Your Ref: EN010087  
Date: 25 August 2020

**Application by Norfolk Boreas Limited for the Norfolk Boreas Offshore Windfarm  
The Examining Authority's fifth round of written questions and requests for  
information (ExQ5) Issued on 11 August 2020**

Please accept this letter as Norfolk County Councils (NCC) written submissions in its capacity as local highway authority in response to the ExA's fifth round of written questions and requests for information.

13 APPENDIX 6 SCHEME OF HIGHWAY MITIGATION (B1145, CAWSTON)

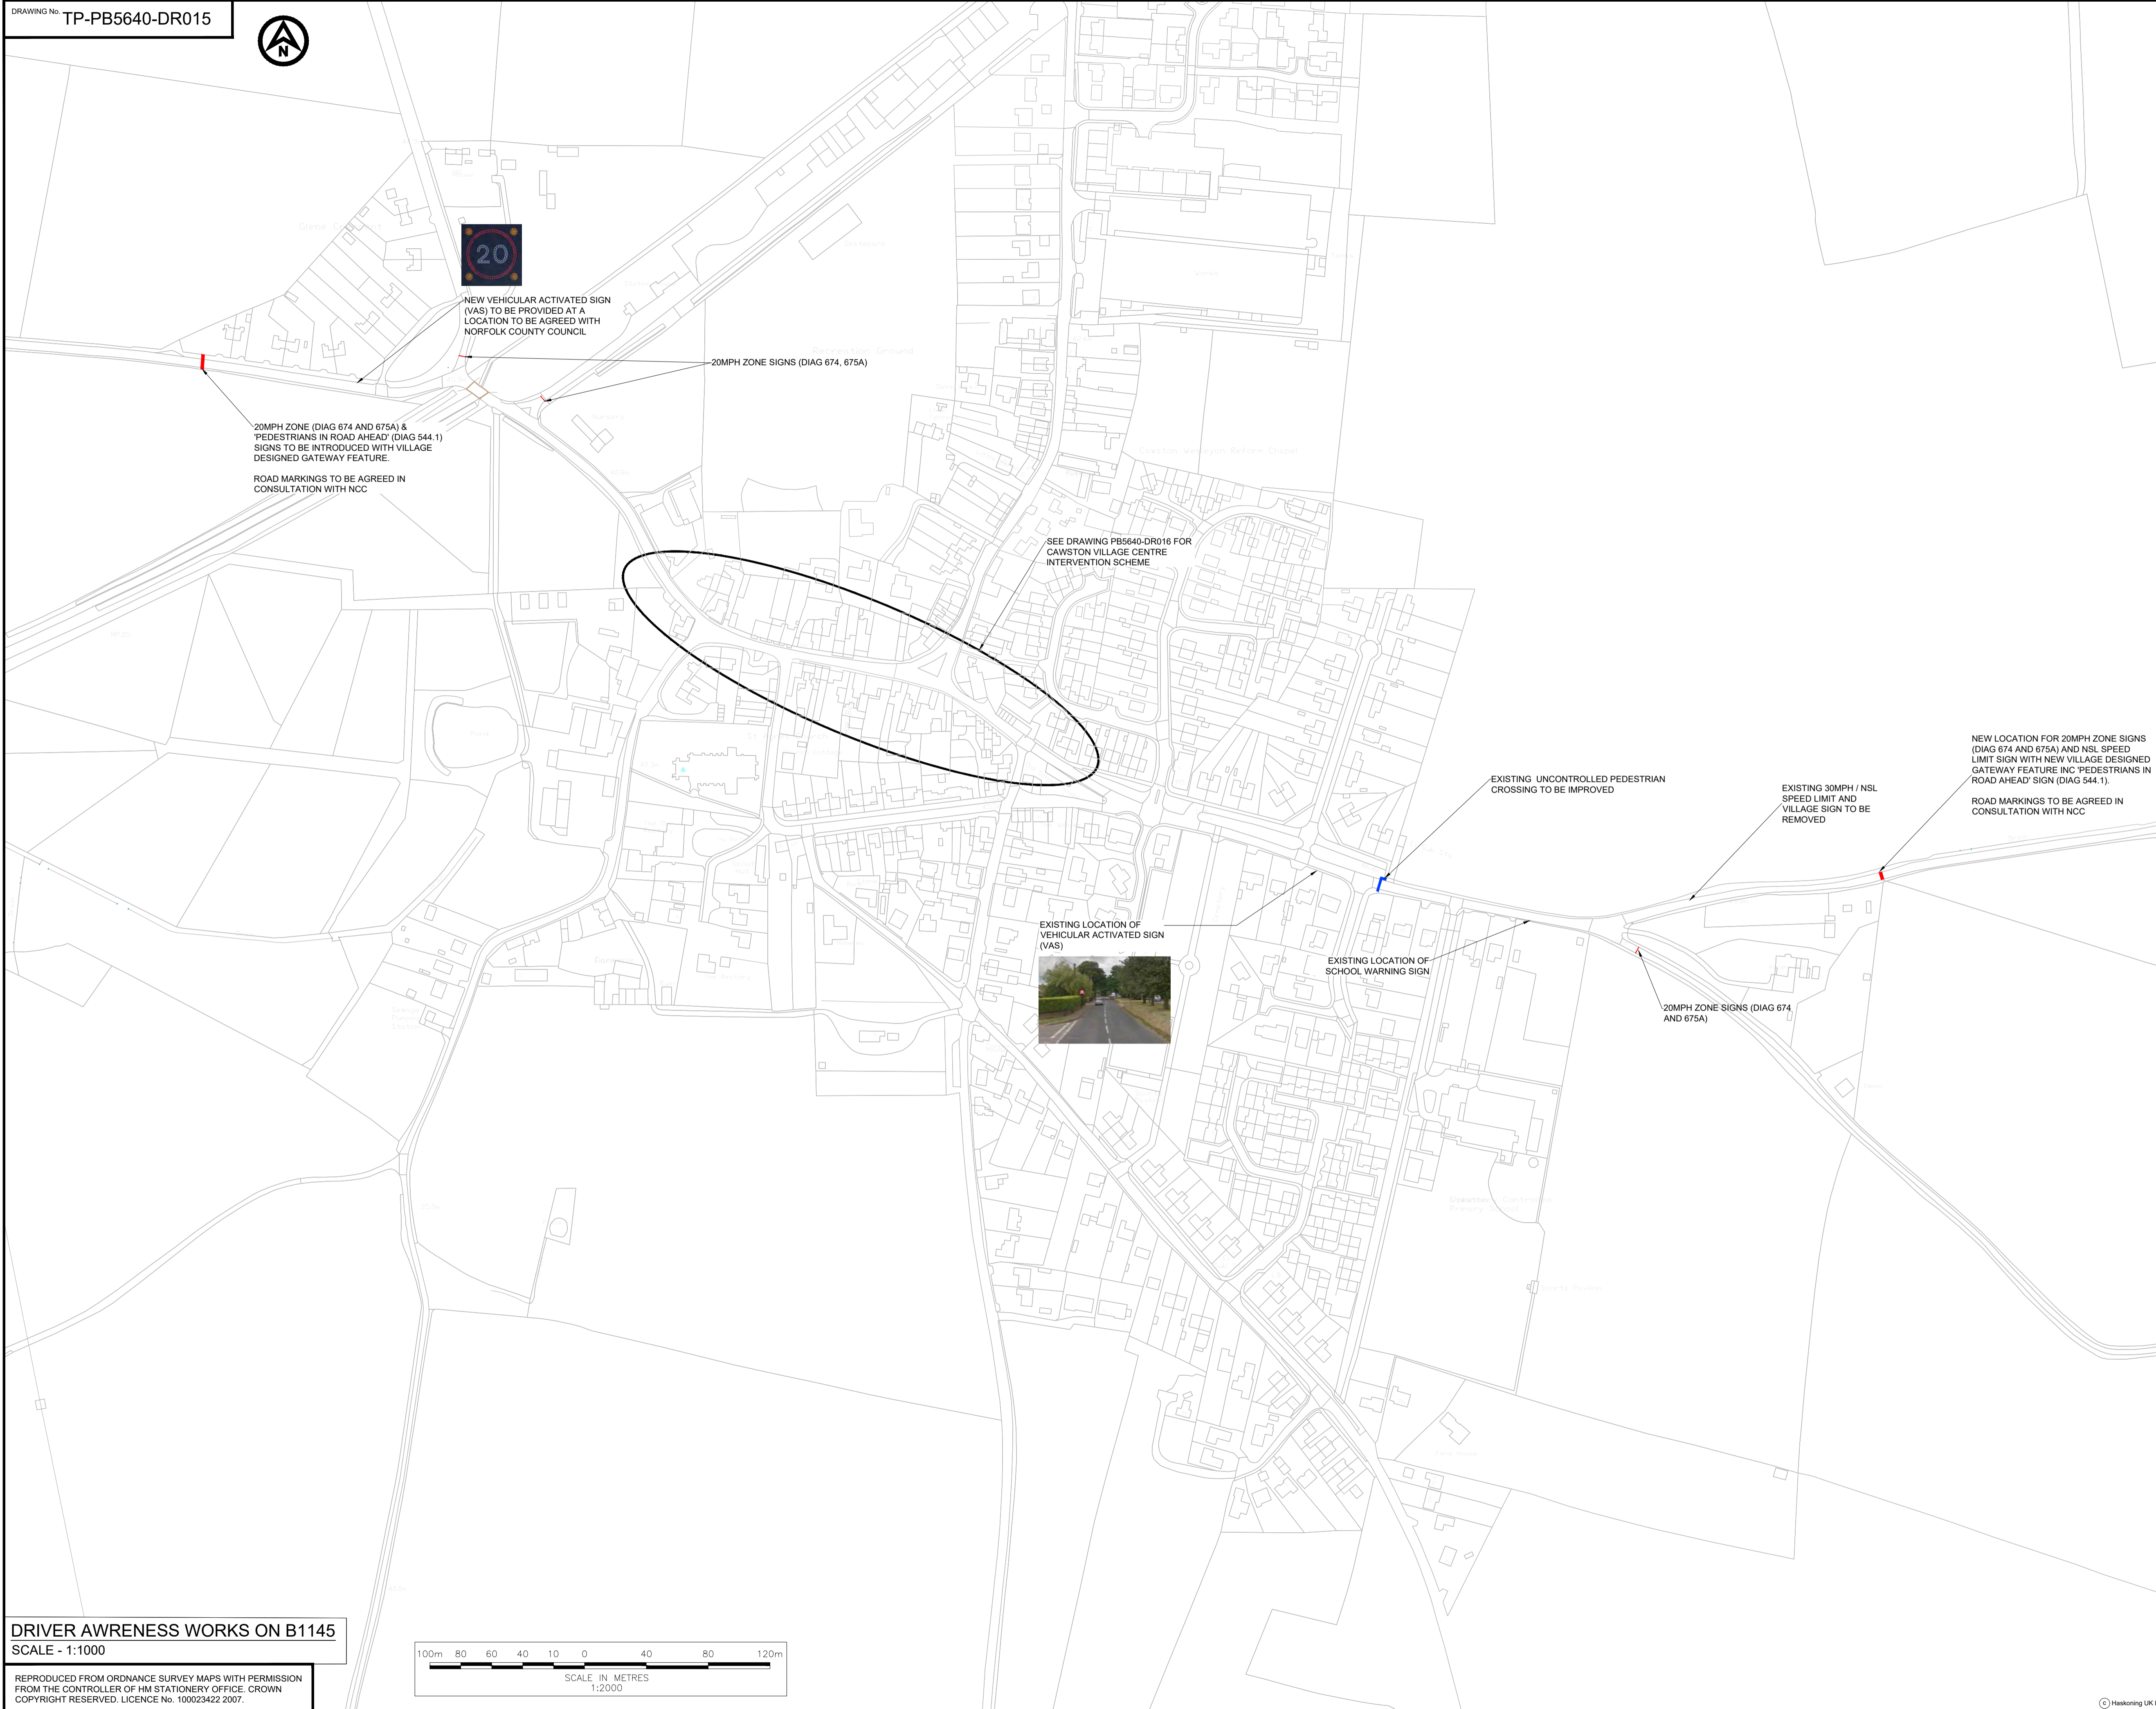
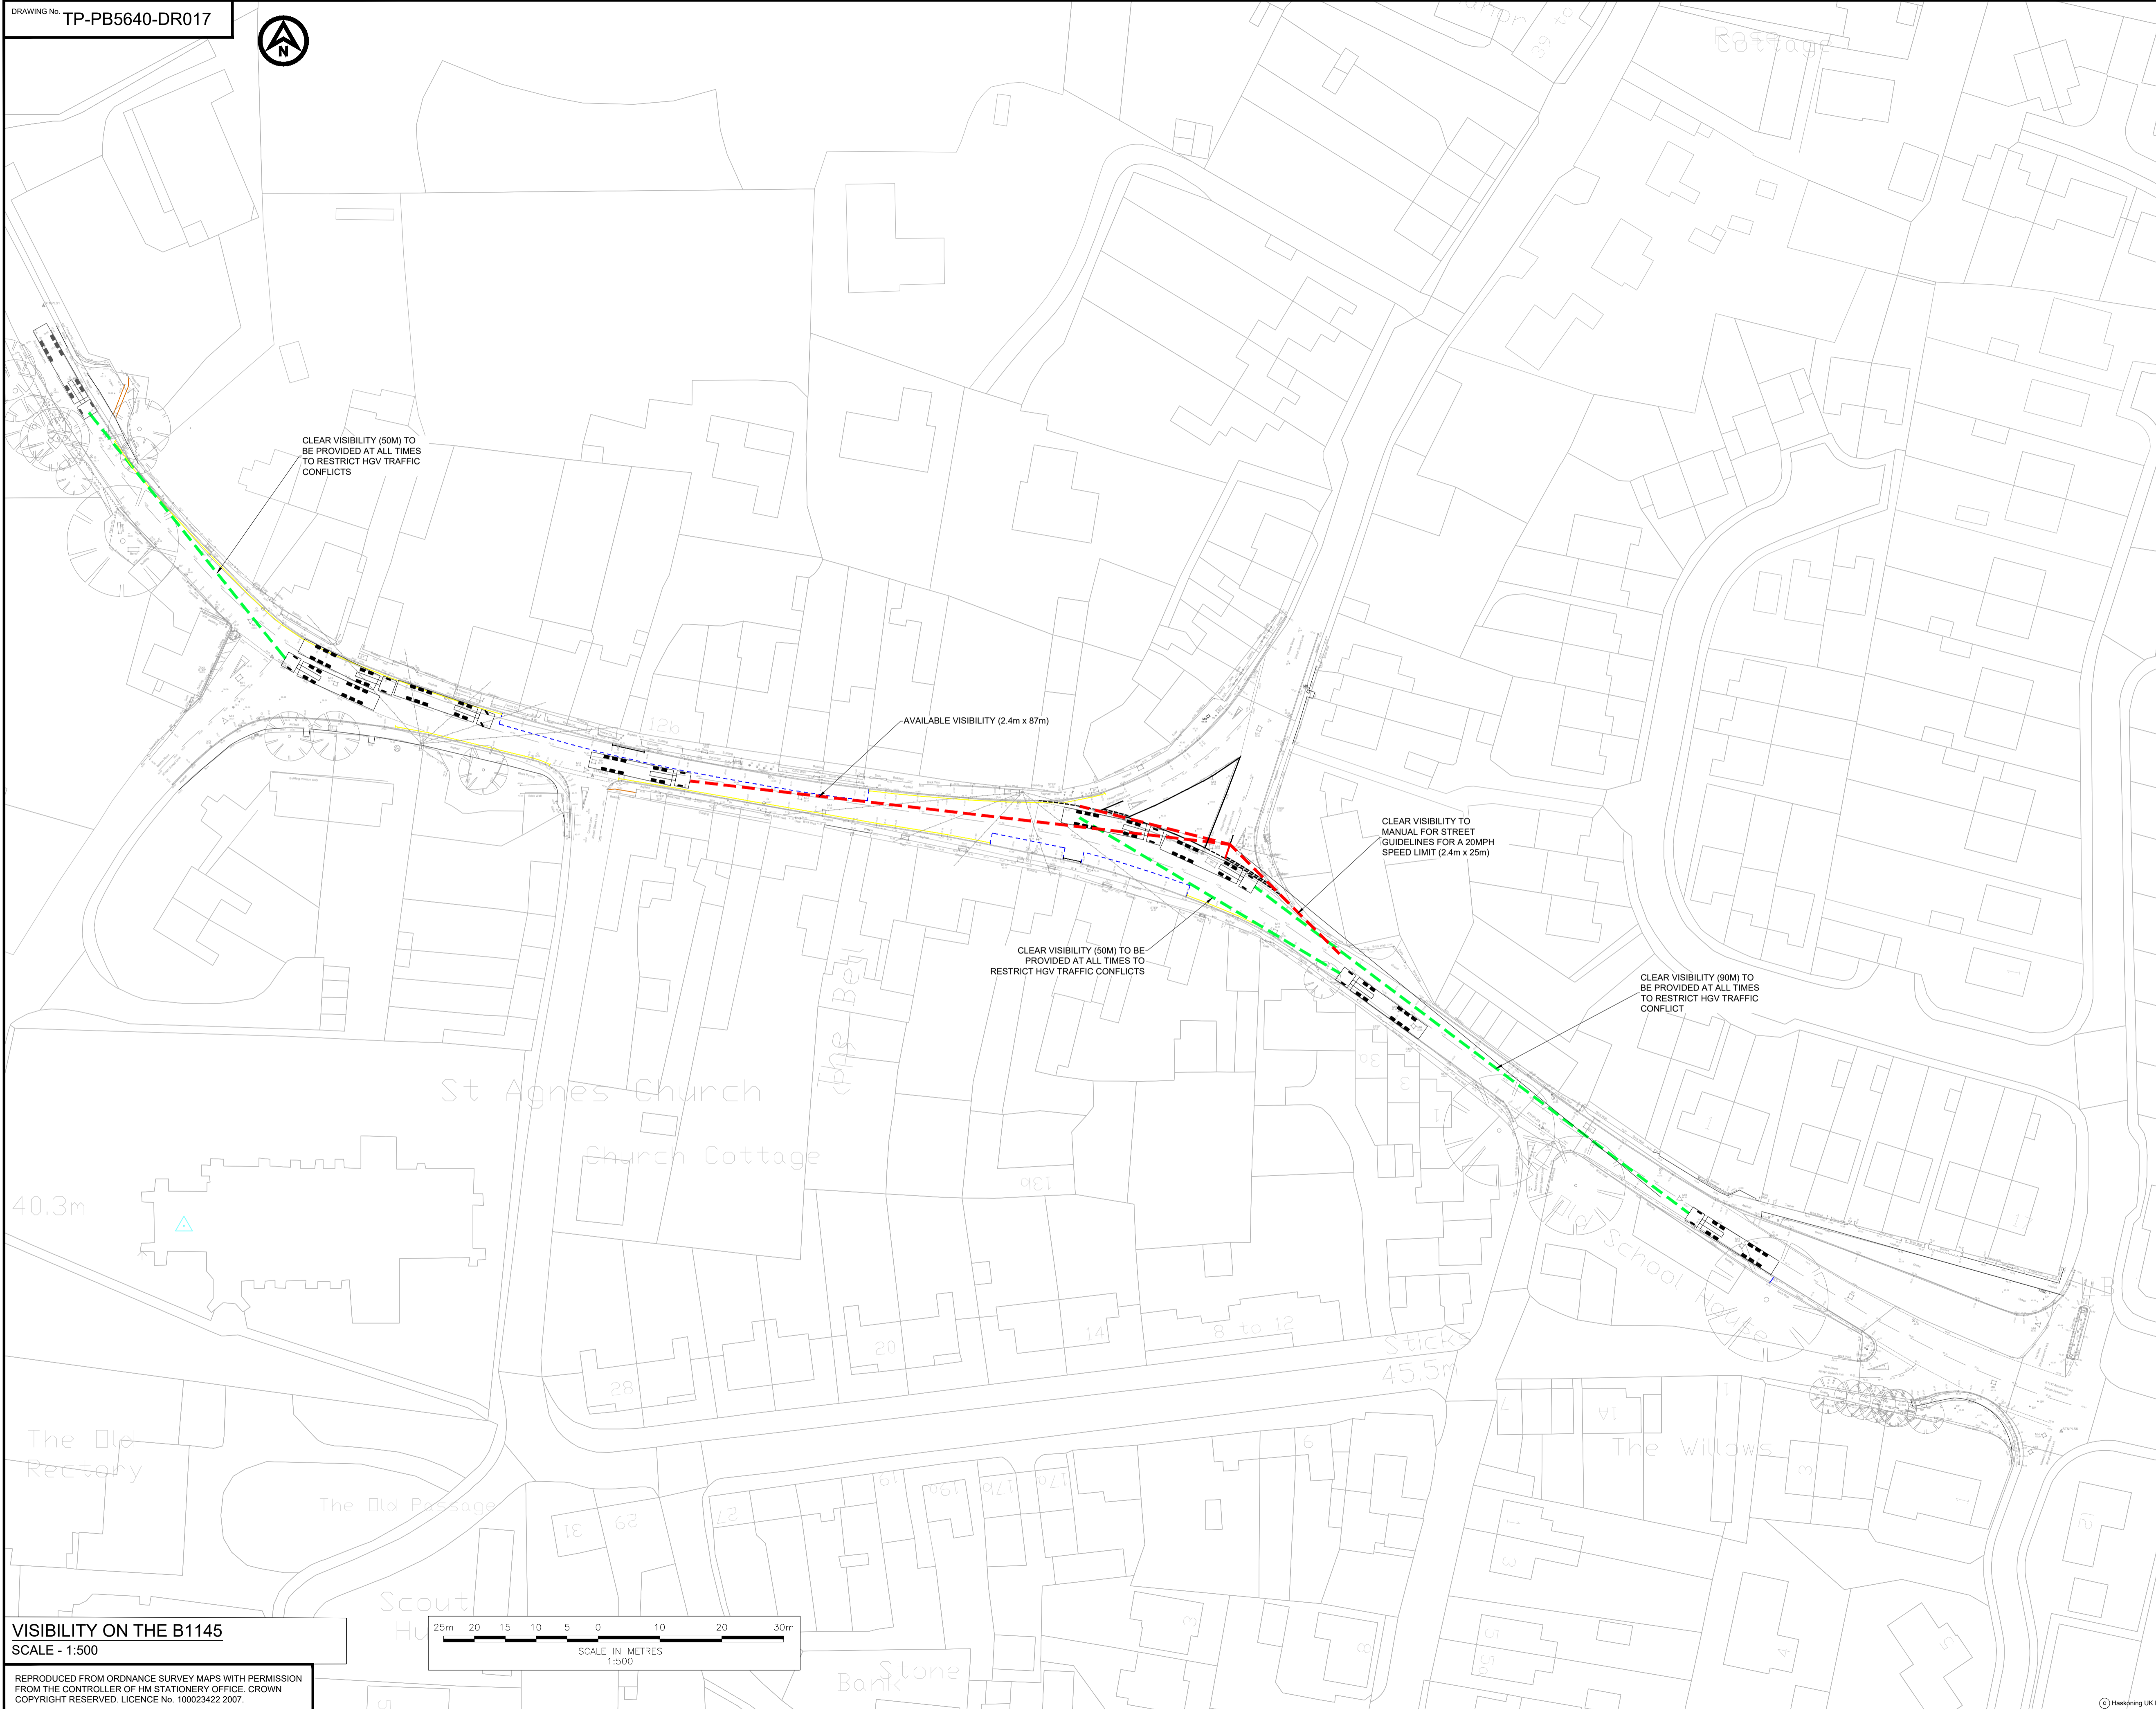
These appear to be issues that we have already discussed at great length as part of the Issue Specific Hearings. NCC is unable to offer any additional advice or offer further suggested amendments to the Cawston Highway Intervention Scheme.

NCC has worked with all three wind farm applicants to ensure the Cawston Highway Intervention Scheme works for Hornsea Three as well as the two Vattenfall projects either in isolation or collectively. Given that all three projects have now committed to using the scheme submitted for Boreas, NCC do not believe the situation is as muddled as suggested. Nevertheless I did write to the Secretary of State on 13 August asking if the text to Requirement 18 of the Hornsea 3 DCO could be amended to make it clear that the revised proposals for Hornsea 3 will be based upon the scheme developed through the Boreas examination.
